Your ref: SSD -10425
File no: MC-20-00005

**SSD10425: Stage 2 – Detailed Development Application - Tallawong Station
Precinct South**

Blacktown Council's requested conditions of consent to SSD 10425: Stage 2 – Detailed Development Application - Tallawong Station Precinct South

Dwg No. DA-110-008, Rev. V

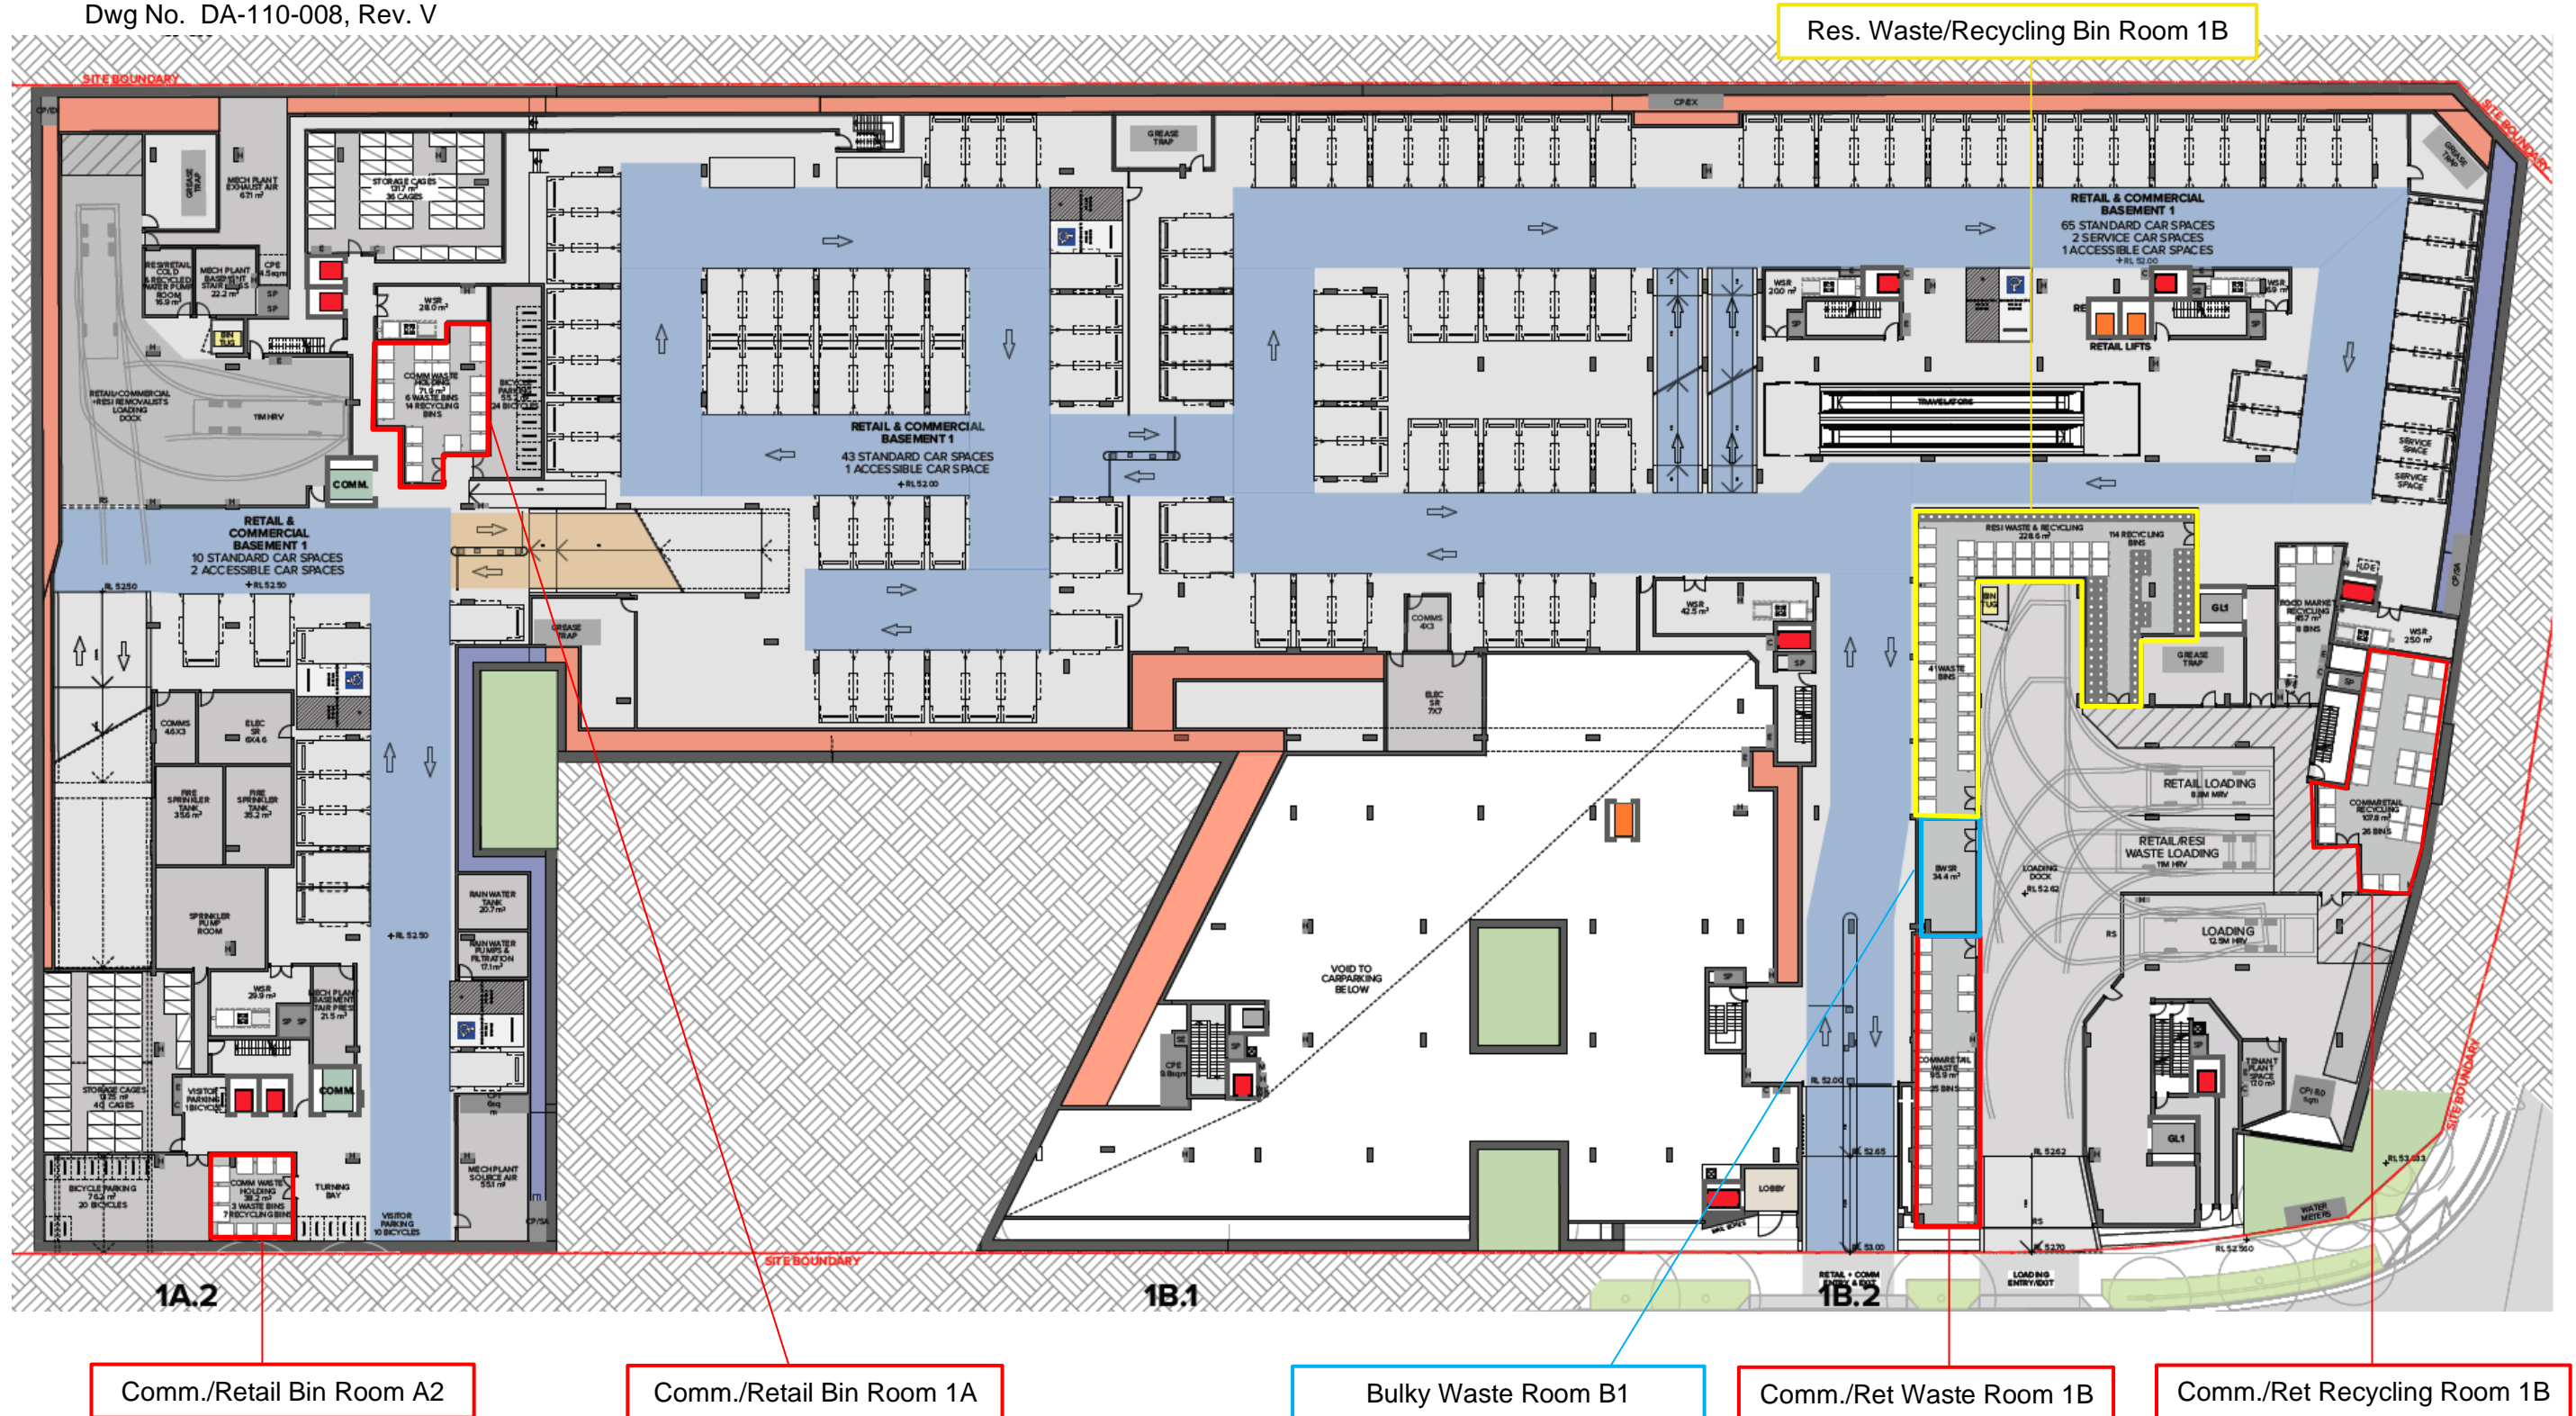
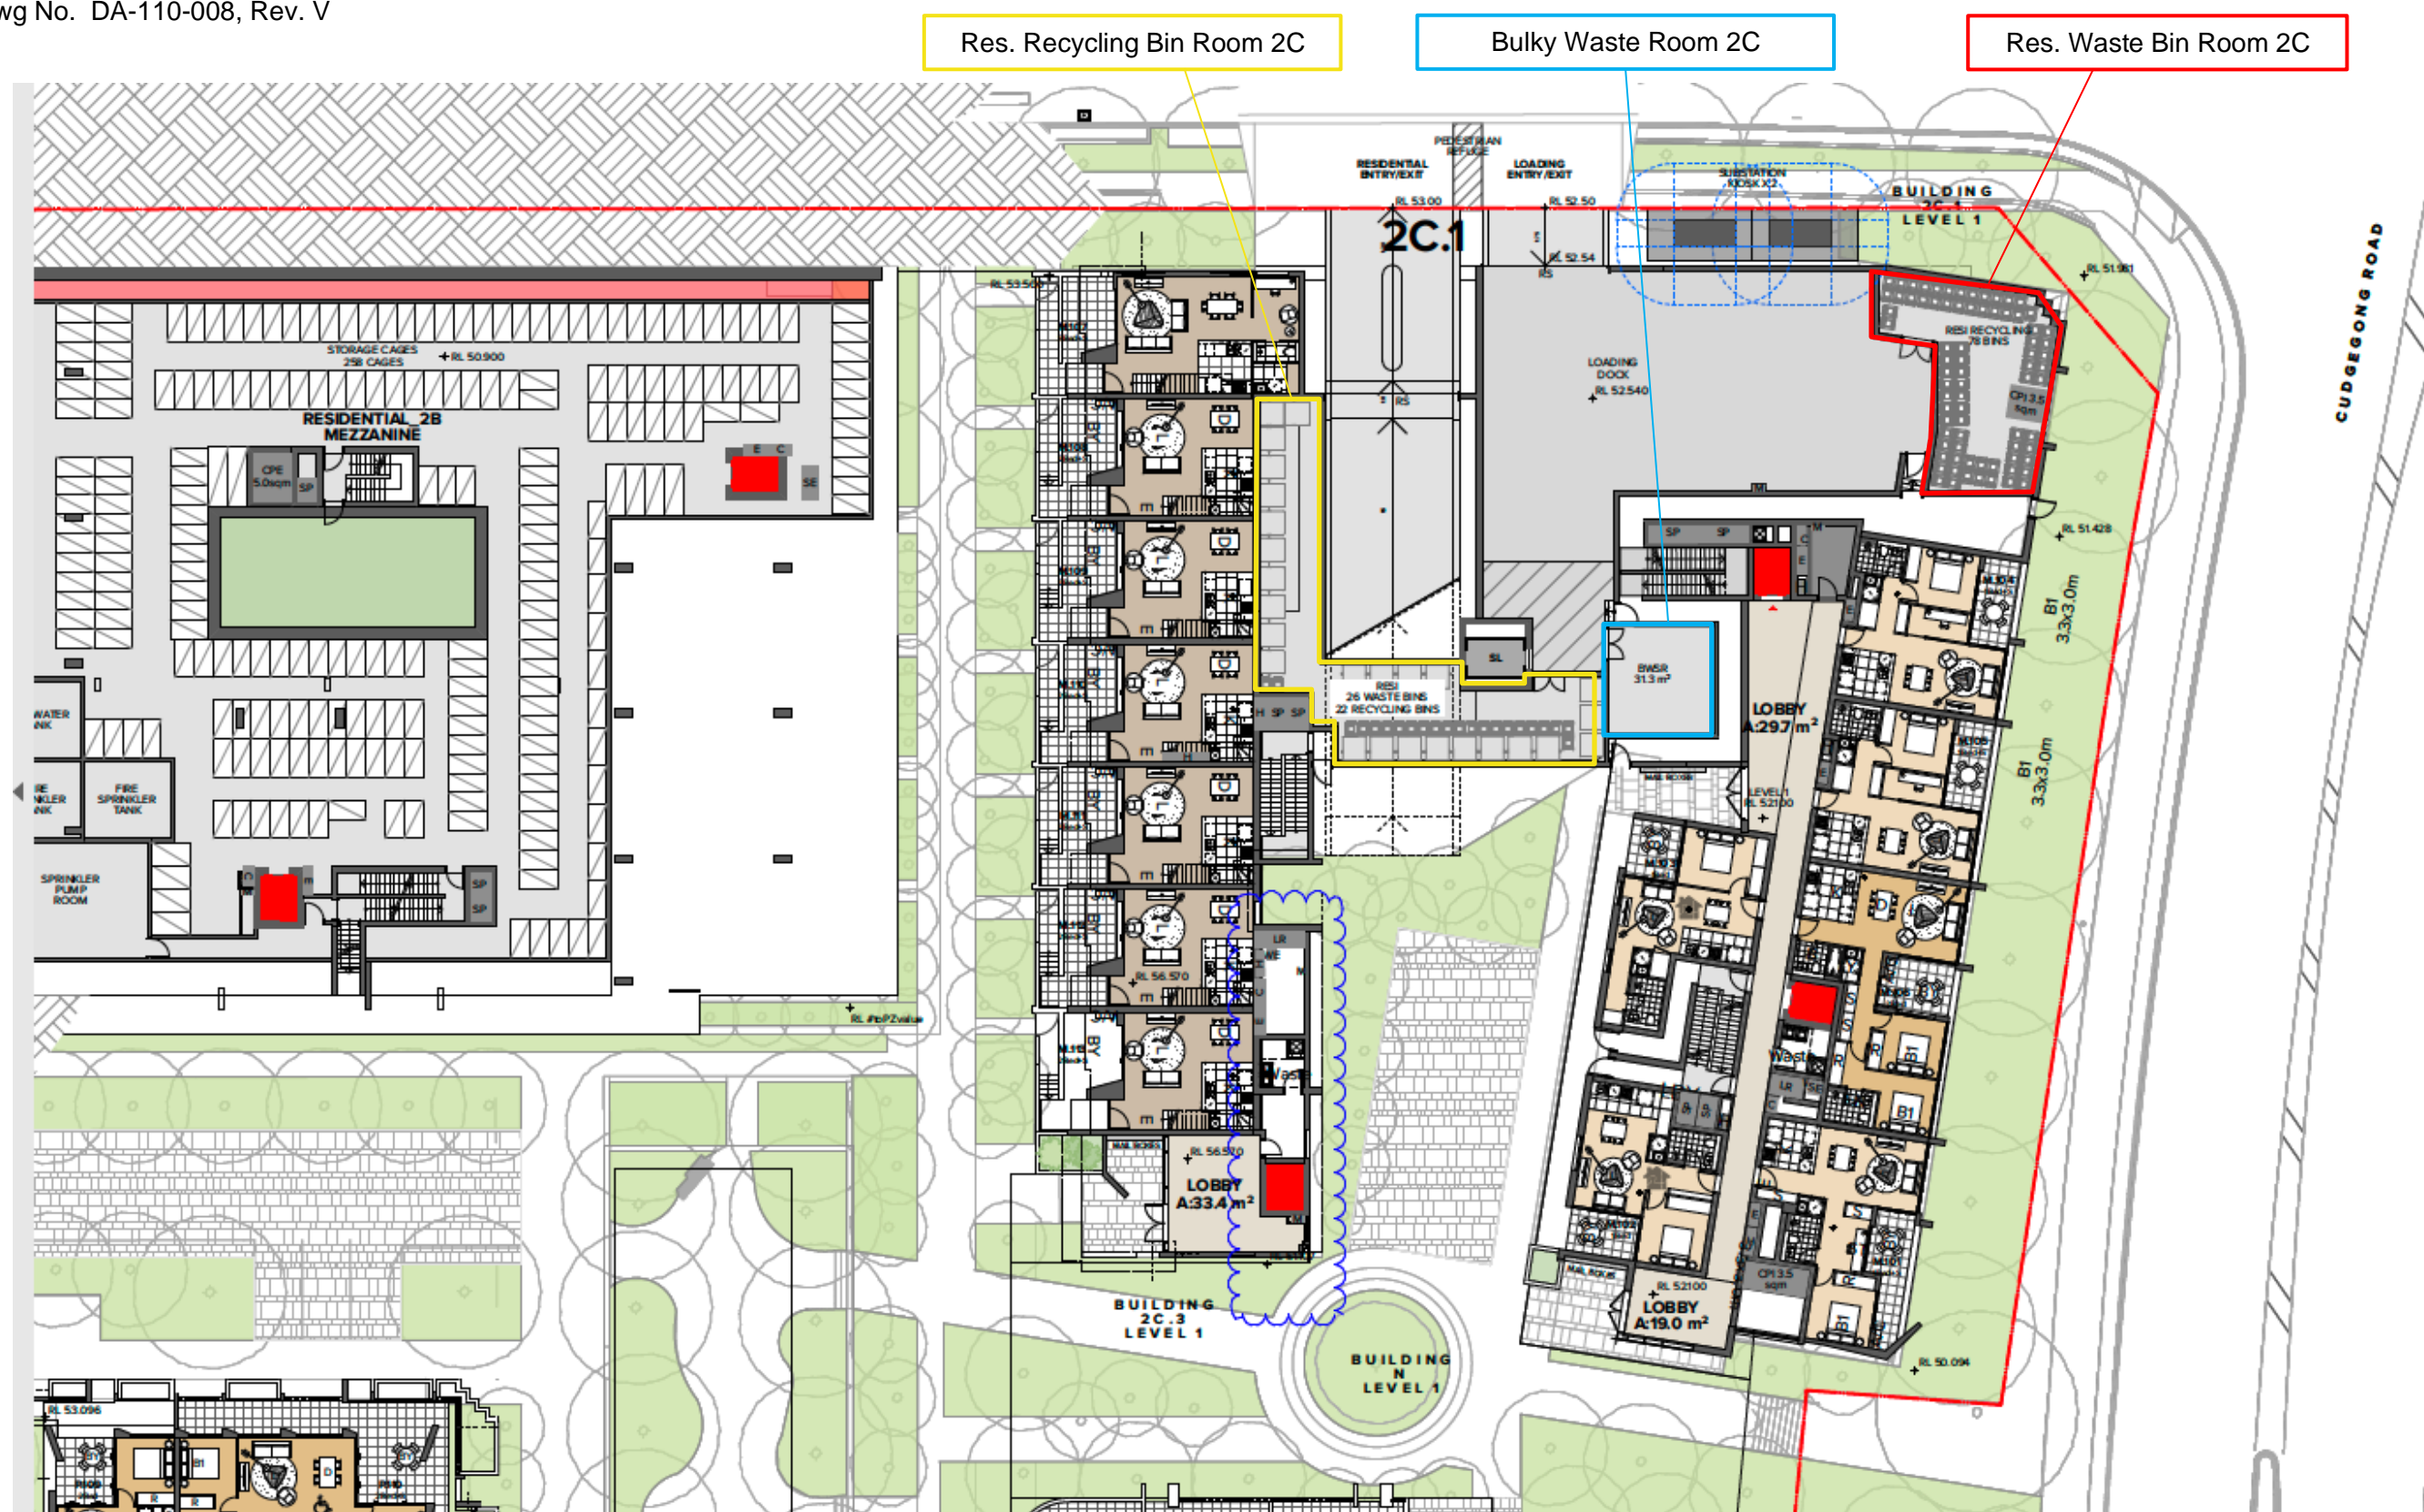
- The applicant must ensure chute discharge rooms are located on the same level as waste rooms to facilitate the movement of bins. Split level locations require dependence on bin movement aids that must traverse ramps and the path of other vehicles. This must be demonstrated to the satisfaction of the consent authority.
- The applicant must ensure the waste chute room is an enclosed space and includes a 240L recycling bin. This must be demonstrated on amended plans.

## APPENDIX A.4 STAGE 2 – BUILDING 2D.1, LEVEL 1

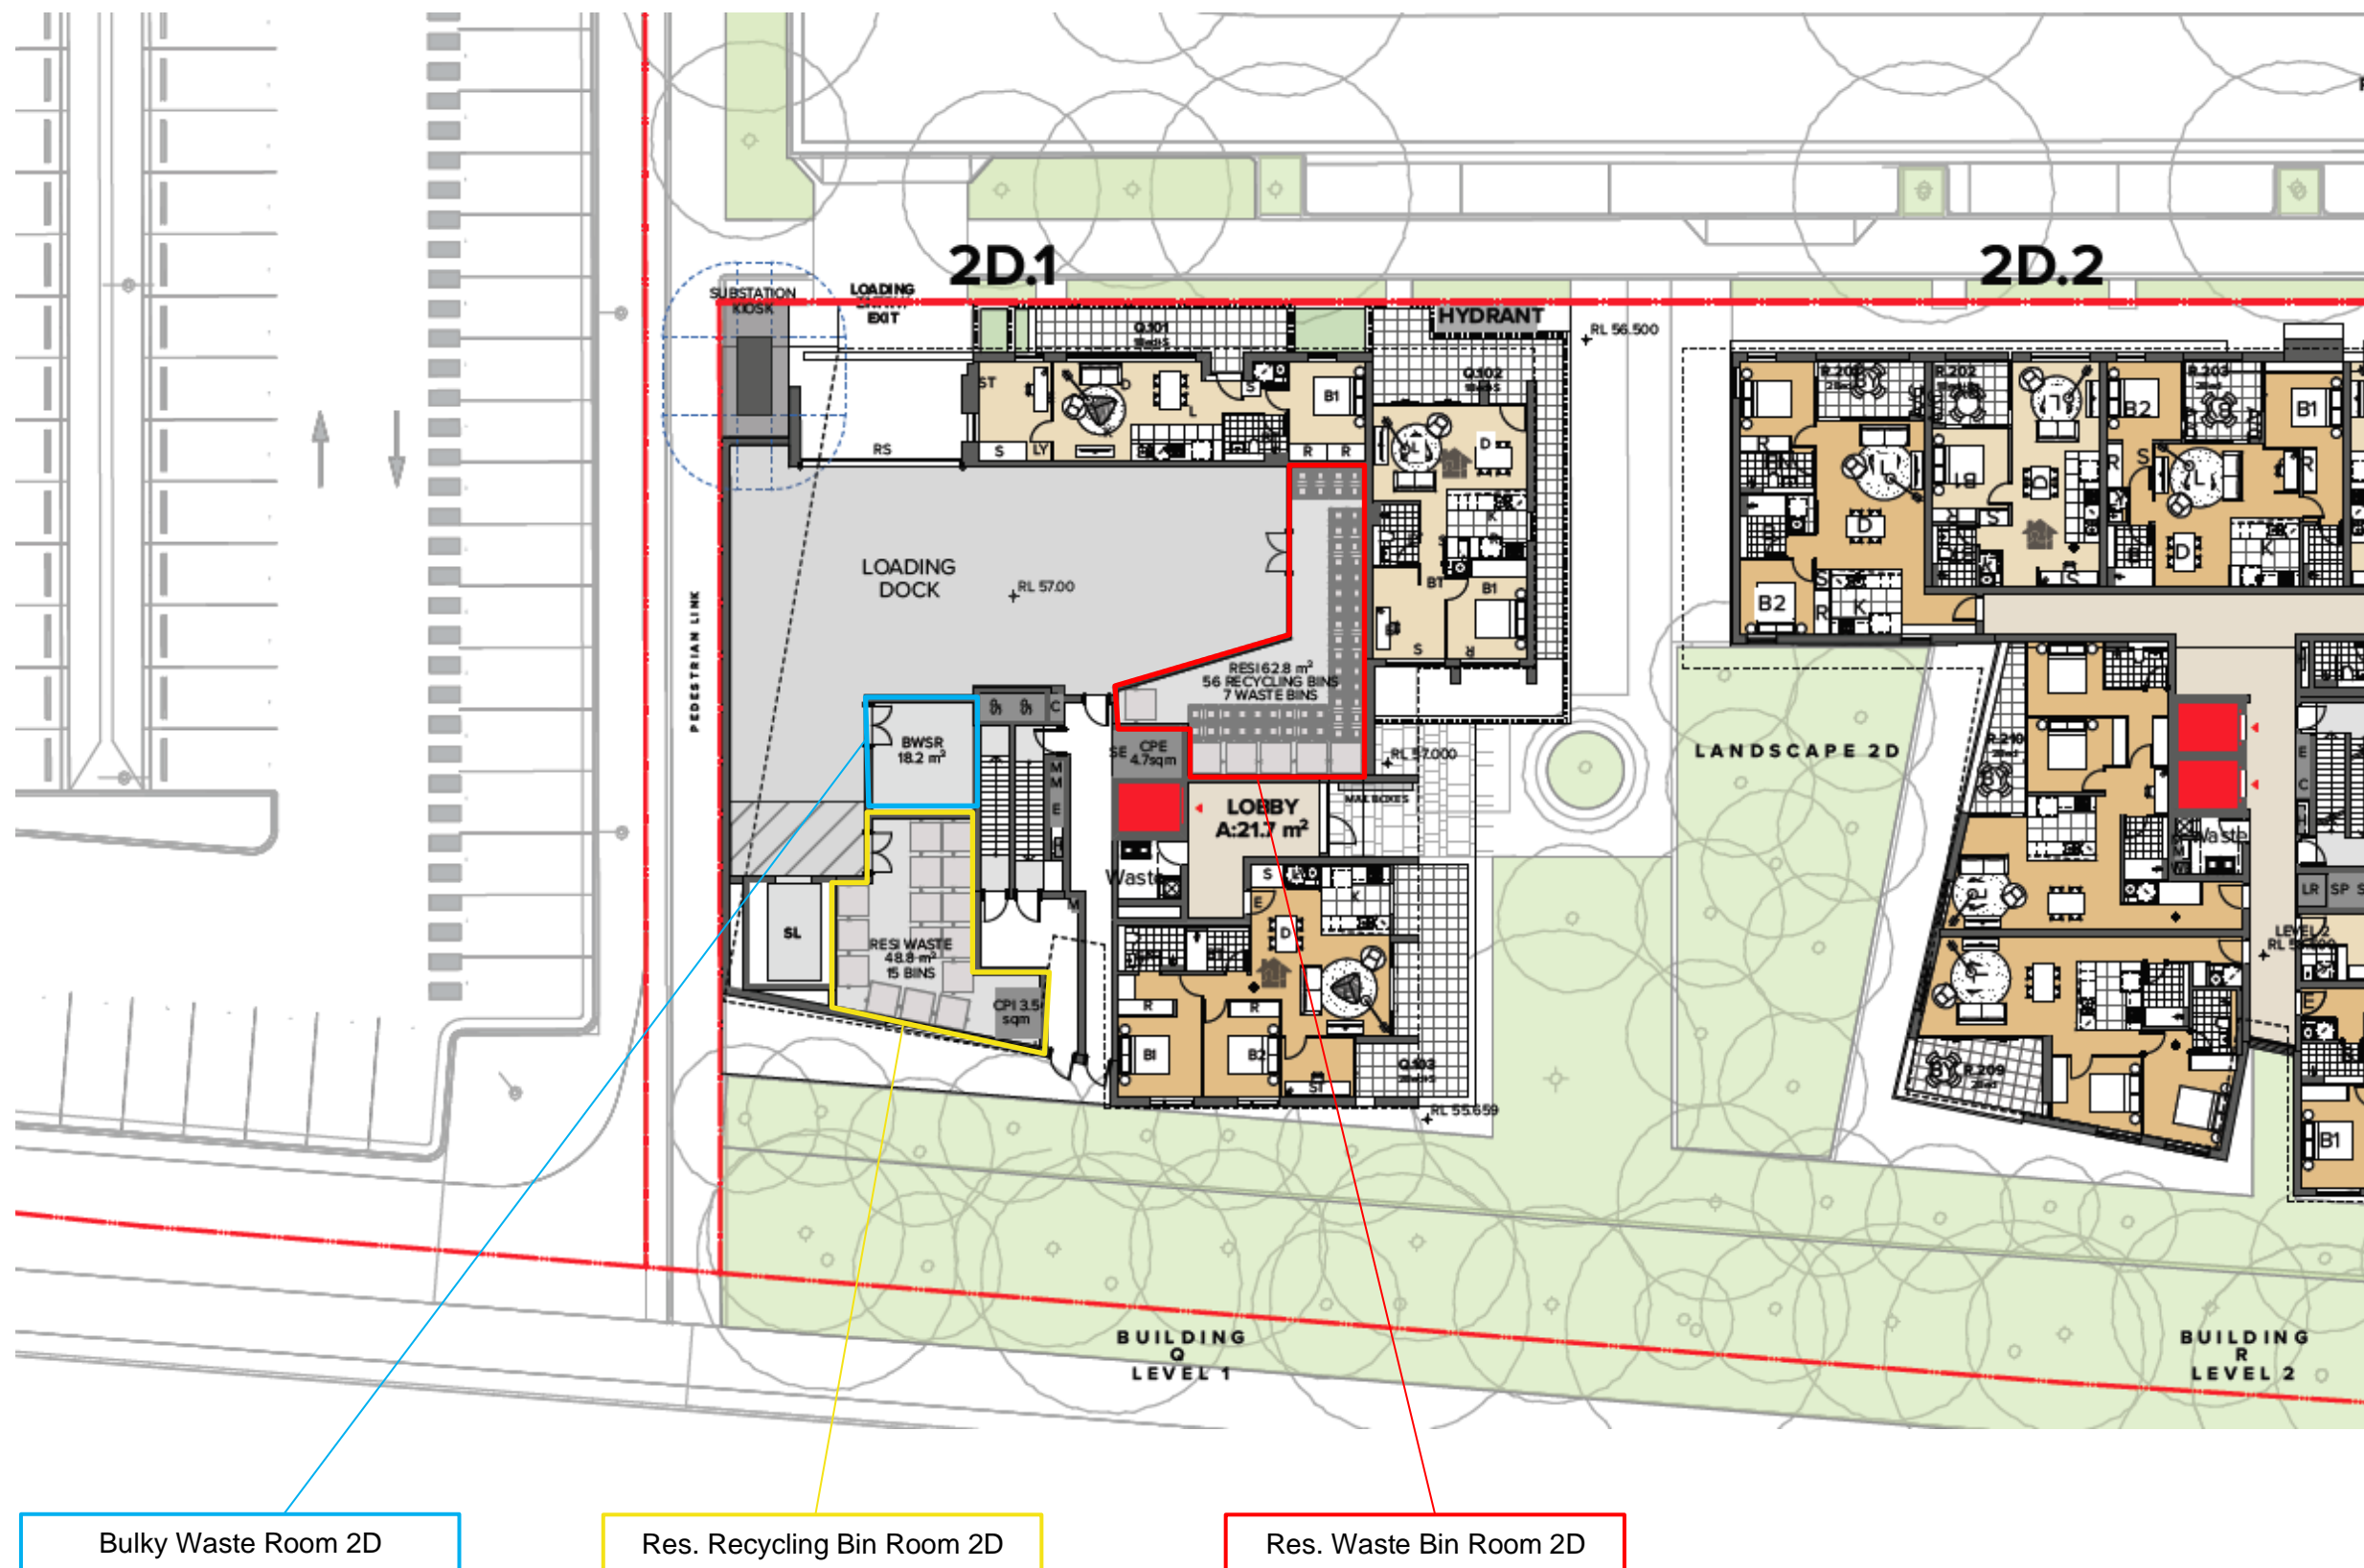
- The applicant must reconfigure access to the bulky waste room as it makes the practical use of this space difficult. Currently, there is insufficient space to move bulk items. This must be demonstrated to the satisfaction of the consent authority.

- The applicant must reconfigure the bin tug and trailer storage area to a more suitable size. This area must accommodate the full length of the vehicle and the trailer.
